Ribble Valley Borough Council
By email

Your ref 3/2025/0801
Our ref DC/25/3013 v2
Date 17-FEB-26

Location: Land to east of Salesbury View Wilpshire.

Proposal: Proposed erection of new residential development comprising 80 new homes, including 30% affordable housing, open space and associated infrastructure.

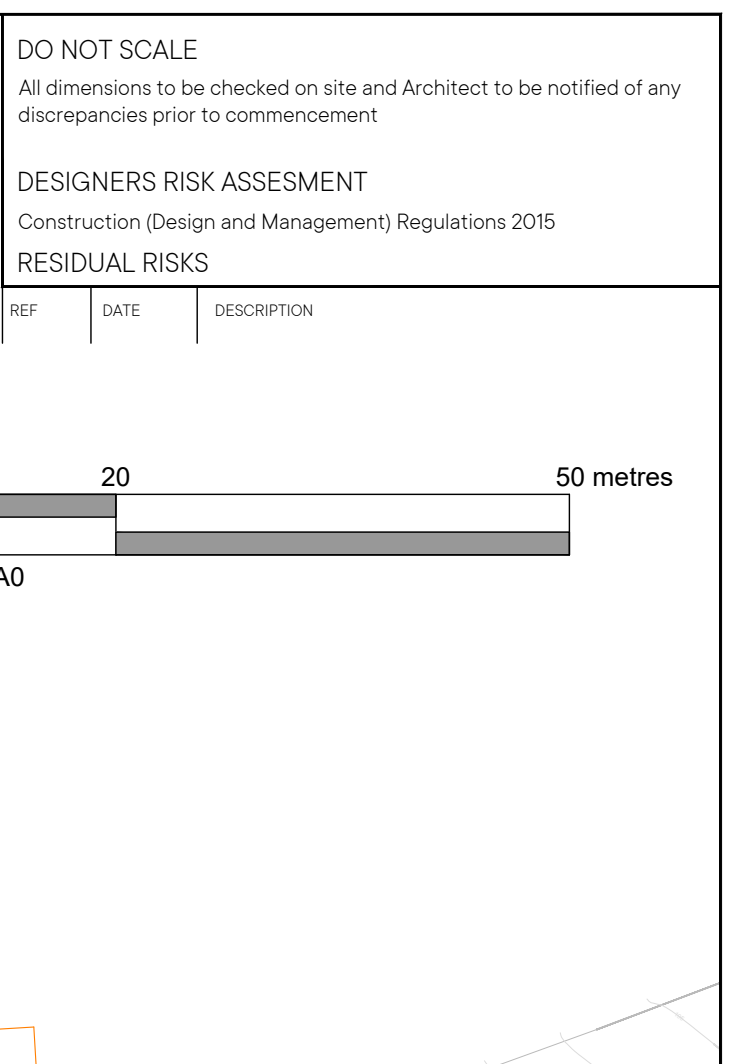
- The removal of permitted development rights in relation to properties 1, 2, 21, 22, 23, 24, 25, 45, 46, 47, 48, 49, 50 and 51 as shown in document reference Proposed Site Layout, Drawing No 101, Revision P25 dated July 2023.
- The inclusion of the below pre-commencement asset protection condition to ensure sufficient protective measures are provided for our large diameter trunk main which is located within the site boundary.
